RE: QuikTrip Store #4299 Final PUD Plan and QuikTrip 4299 Subdivision Filing No. 1 - Final Plat Applicant Responses

Thank you for the comments dated November 1, 2021 regarding the subject development application under Final PUD and Final Plat review. We appreciate you working with us to resolve the comments since their issuance; below is a summary in ***bold and italics*** of our responses that coincide with our related plan revisions.

SHEET TITLE:

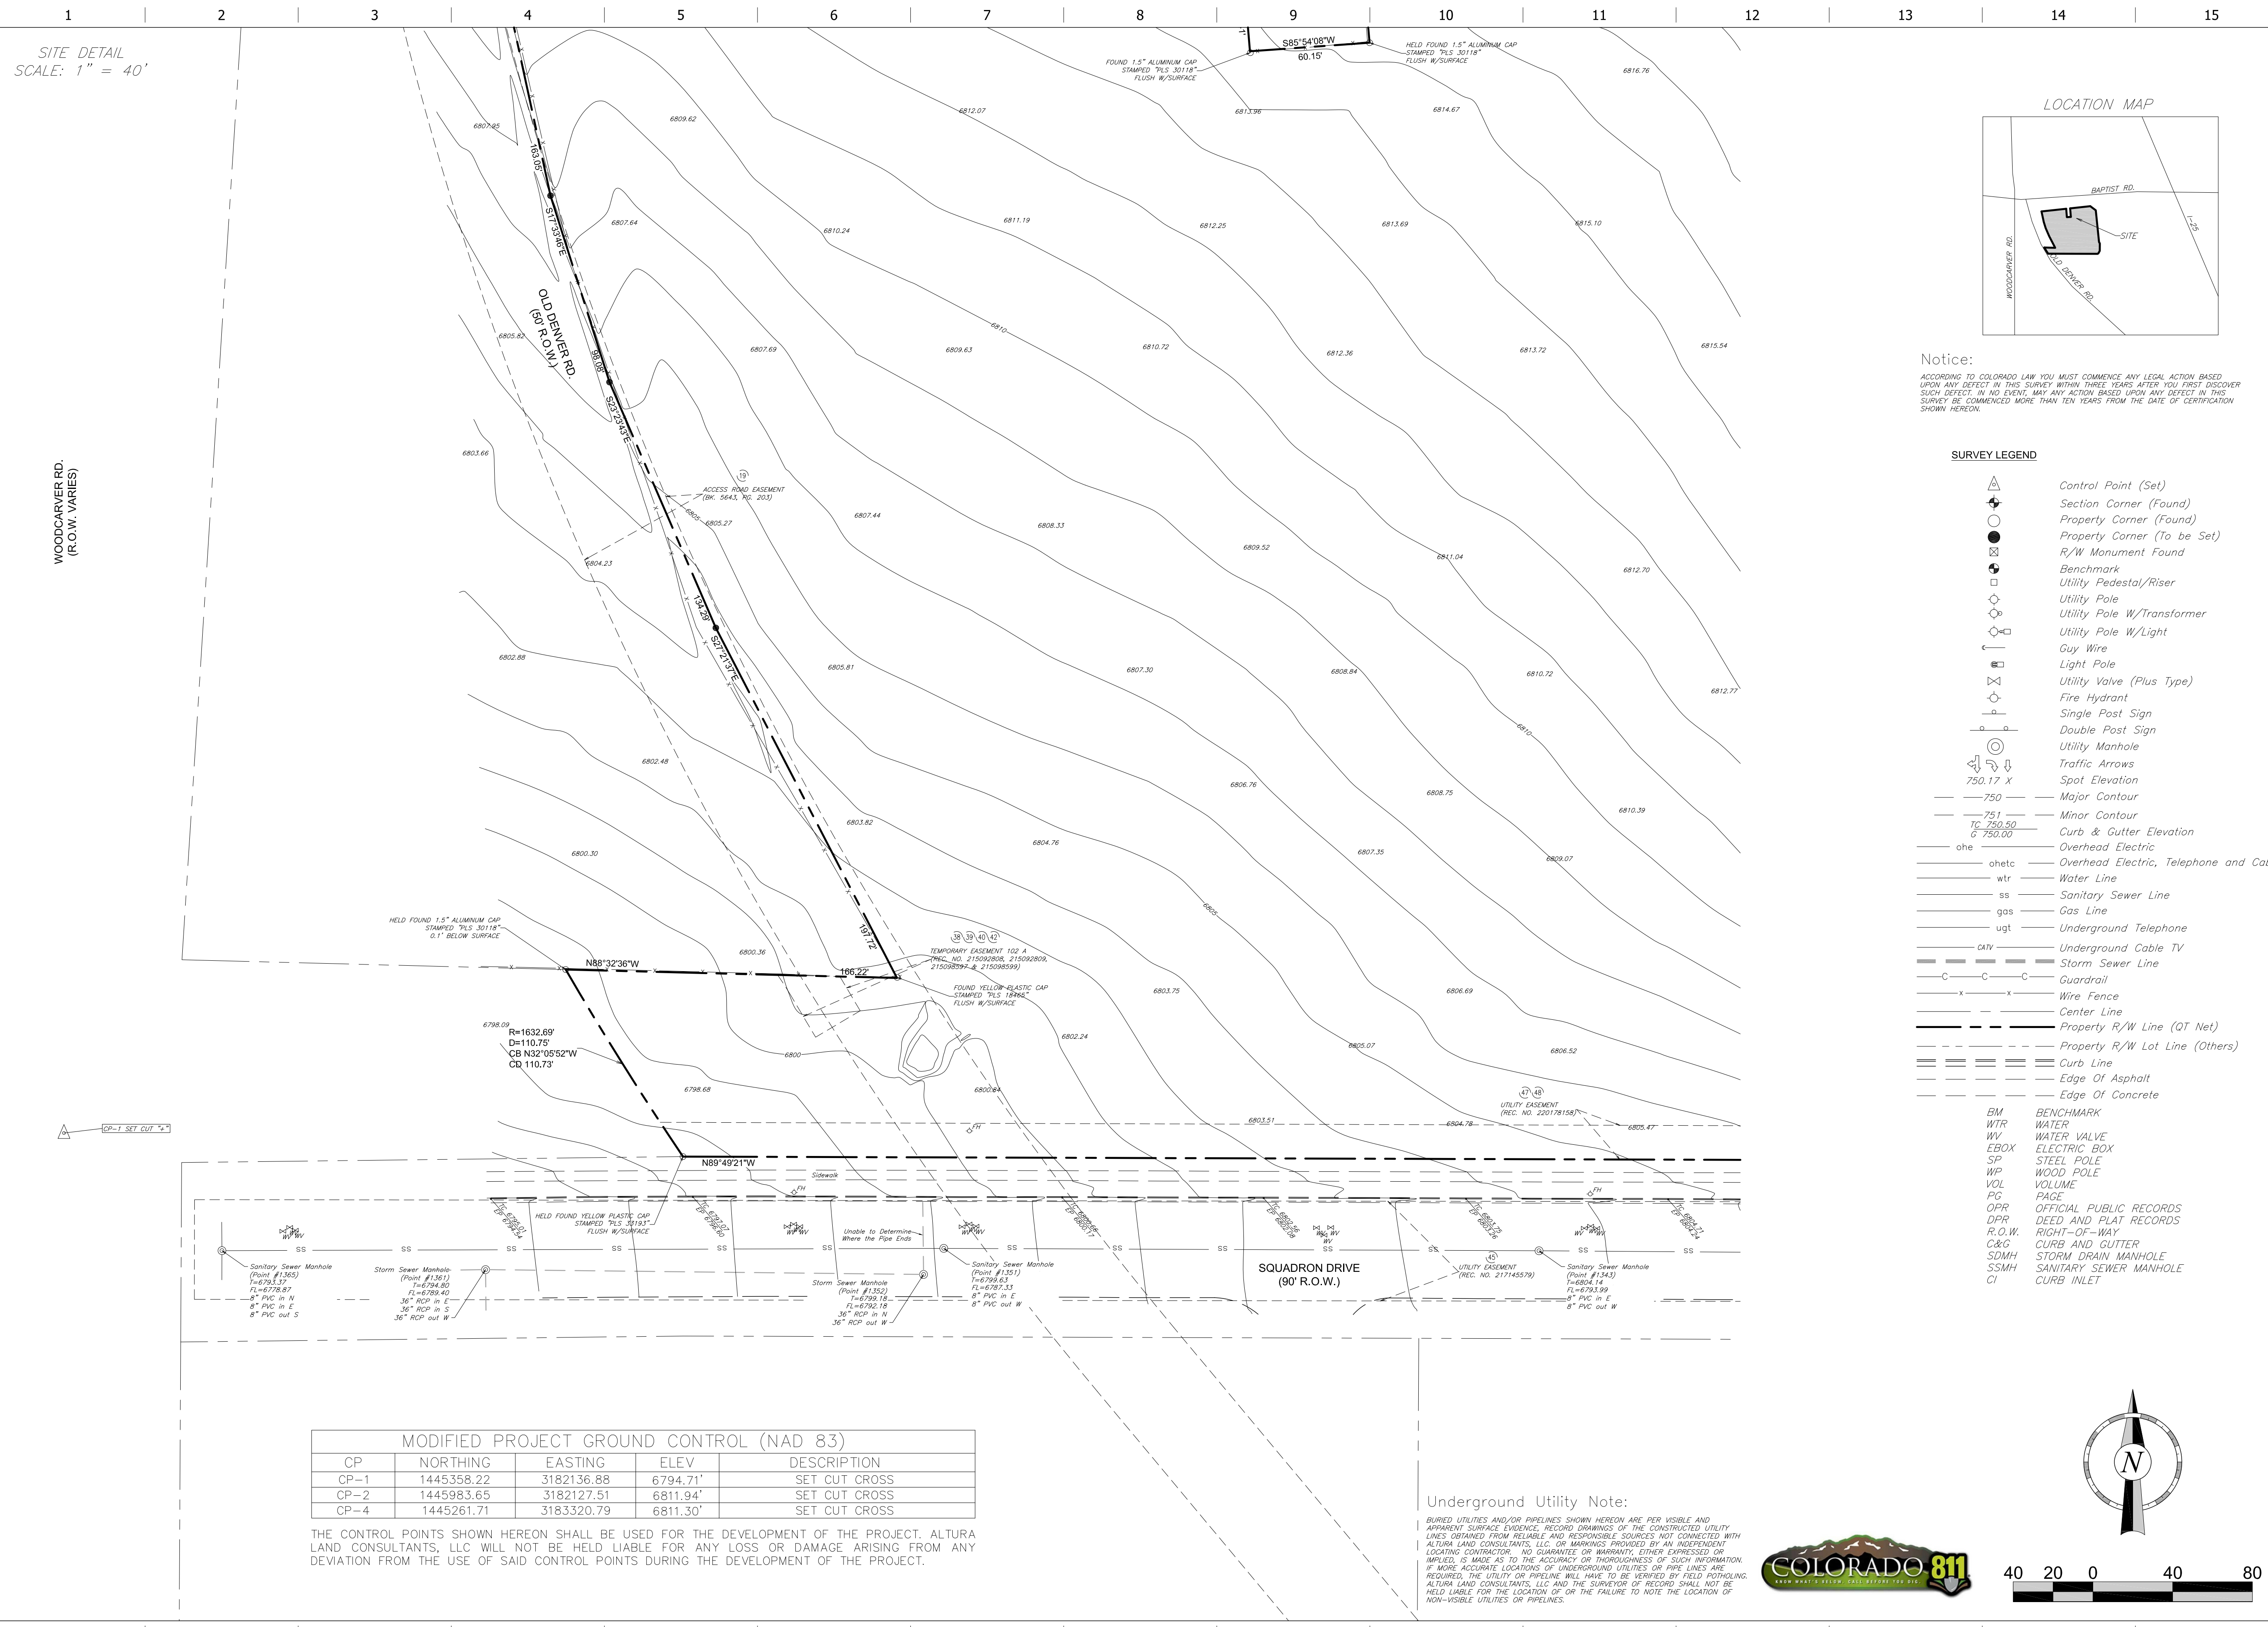
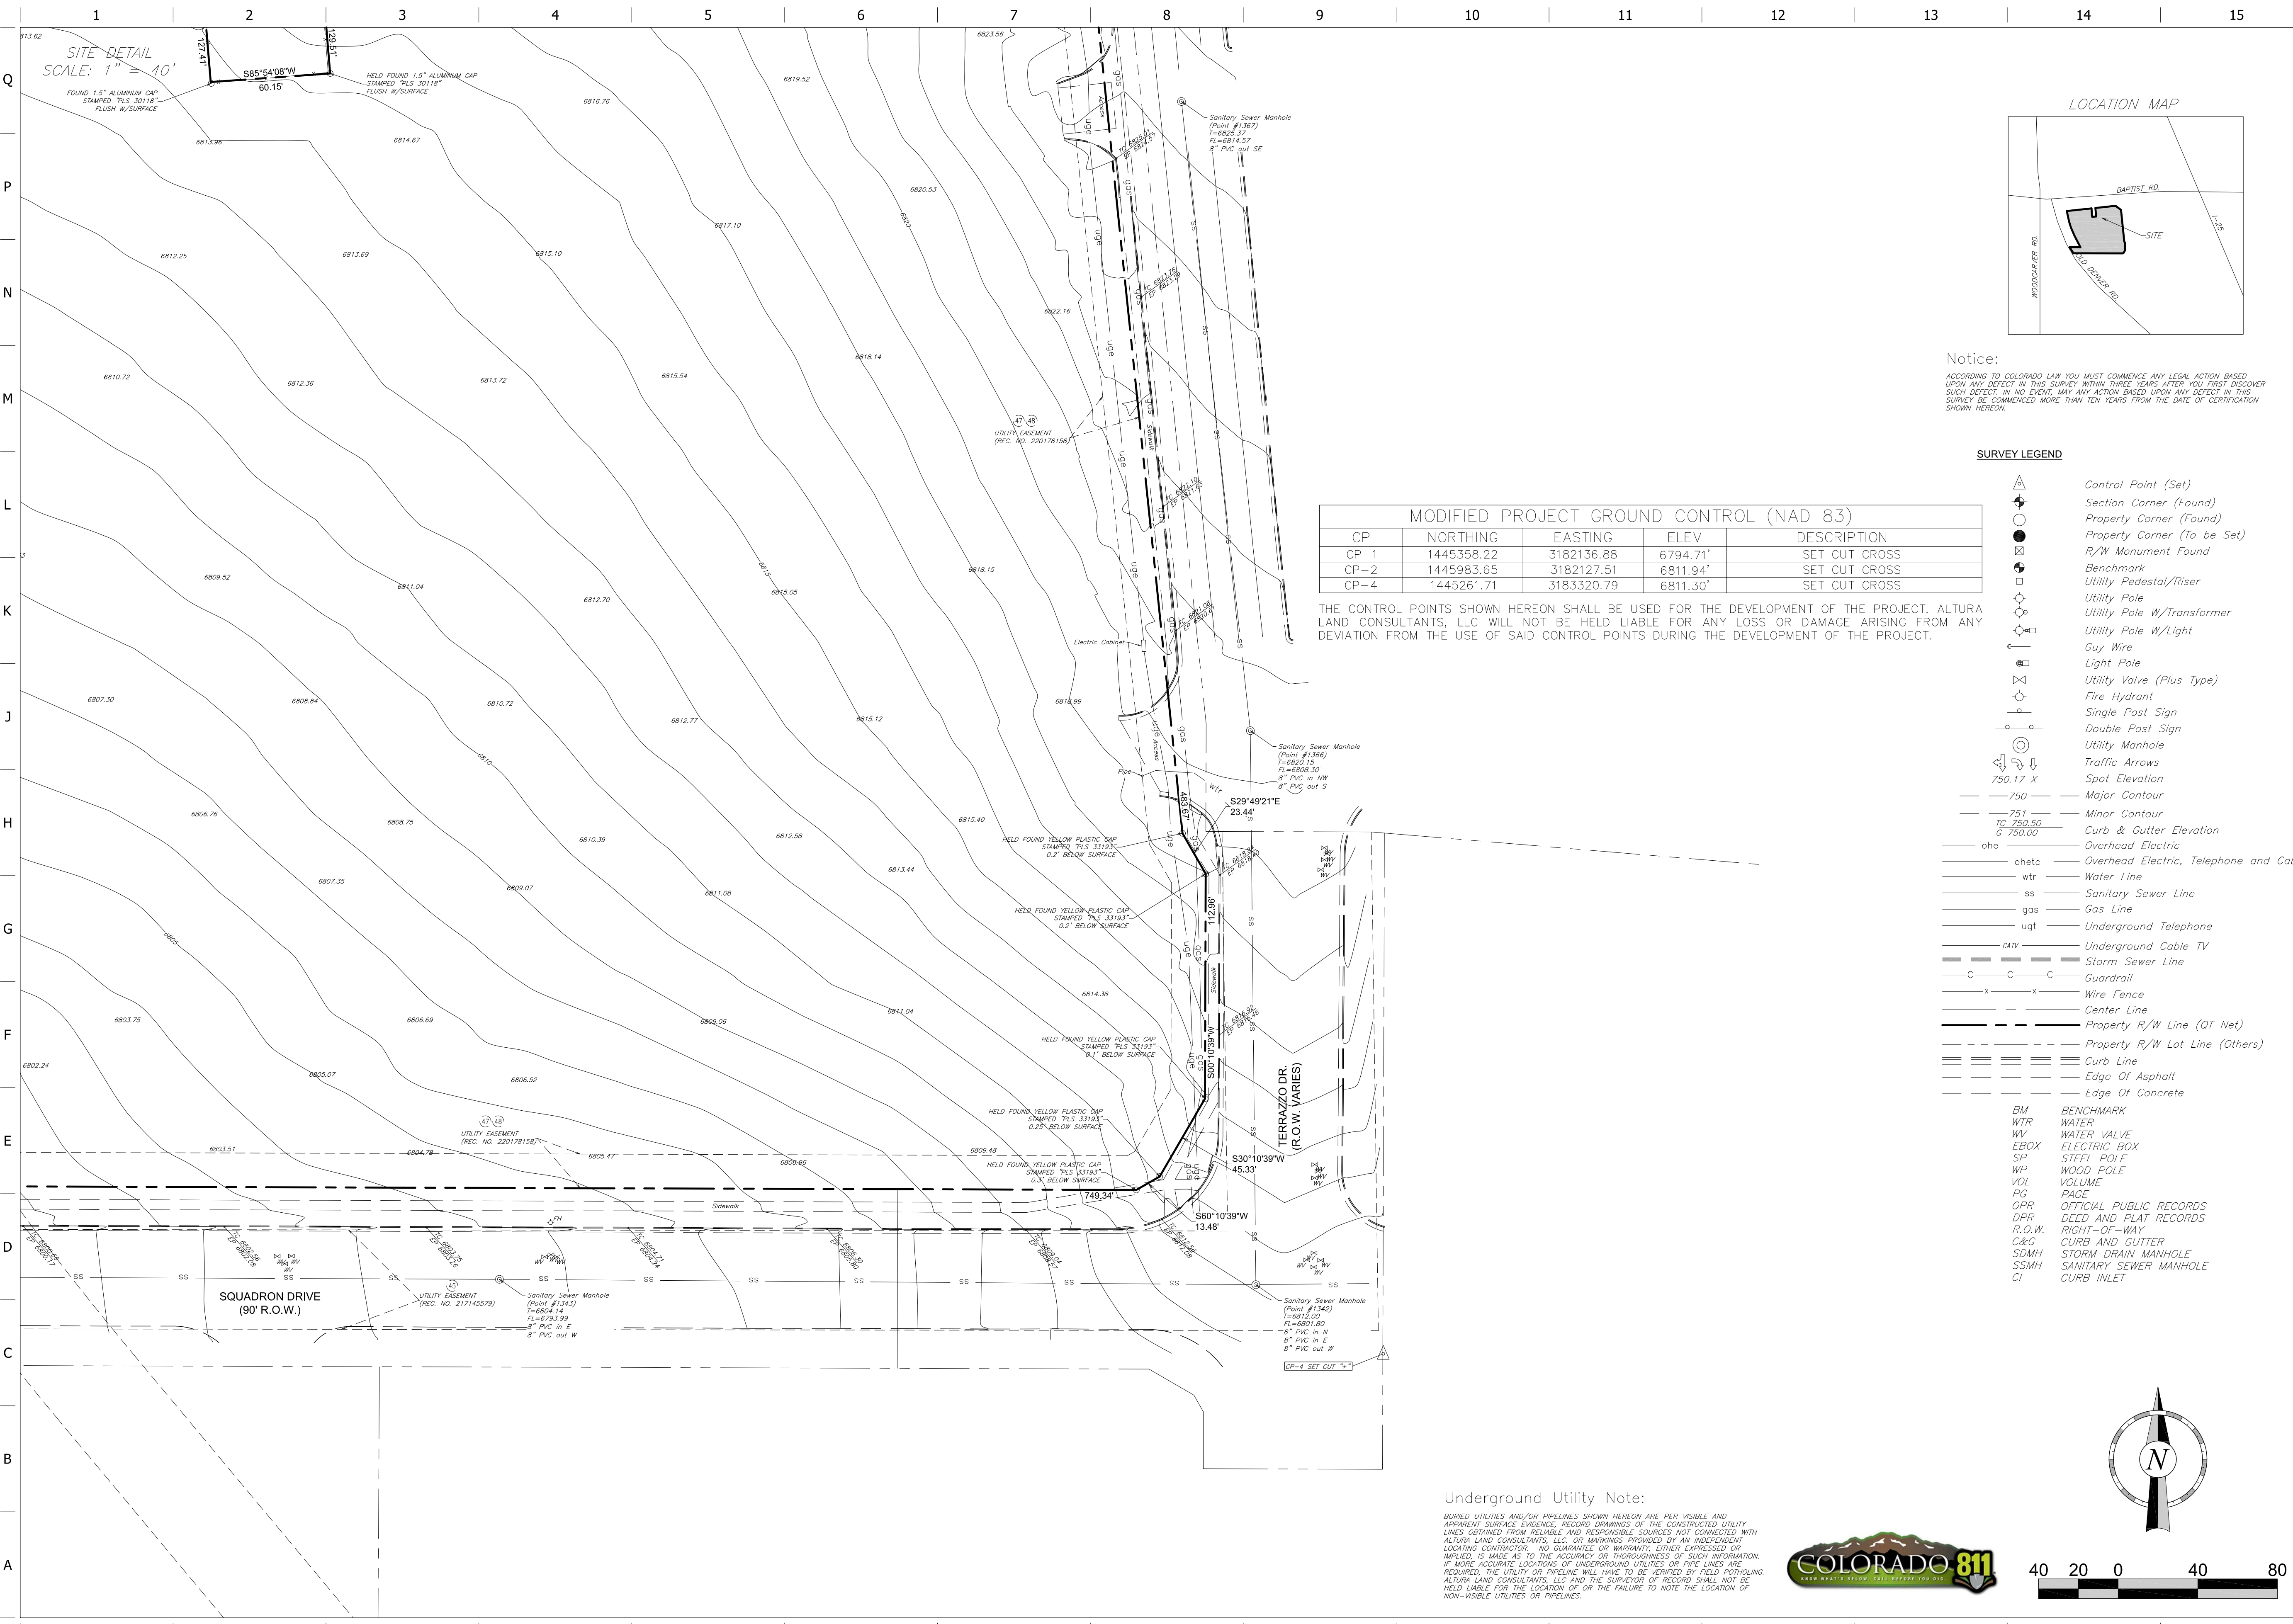
Topographic Survey Plan (Sheets 4, 5, 6, 7, and 8):

13. Only use the legend symbols if shown.

14. There is no need to show the previous Old Denver Road. It is an obsolete road.

15. Please call out Squadron Drive.

Altura Response: This is an ALTA survey that was prepared for this project which must include the appropriate legends. No changes made.

Altura Response: The Old Denver Road has not been vacated, the County Assessor still shows it on the maps as a road and has references made to it from other legal descriptions. No changes made.

Altura Response: Squadron Drive has now been called out.
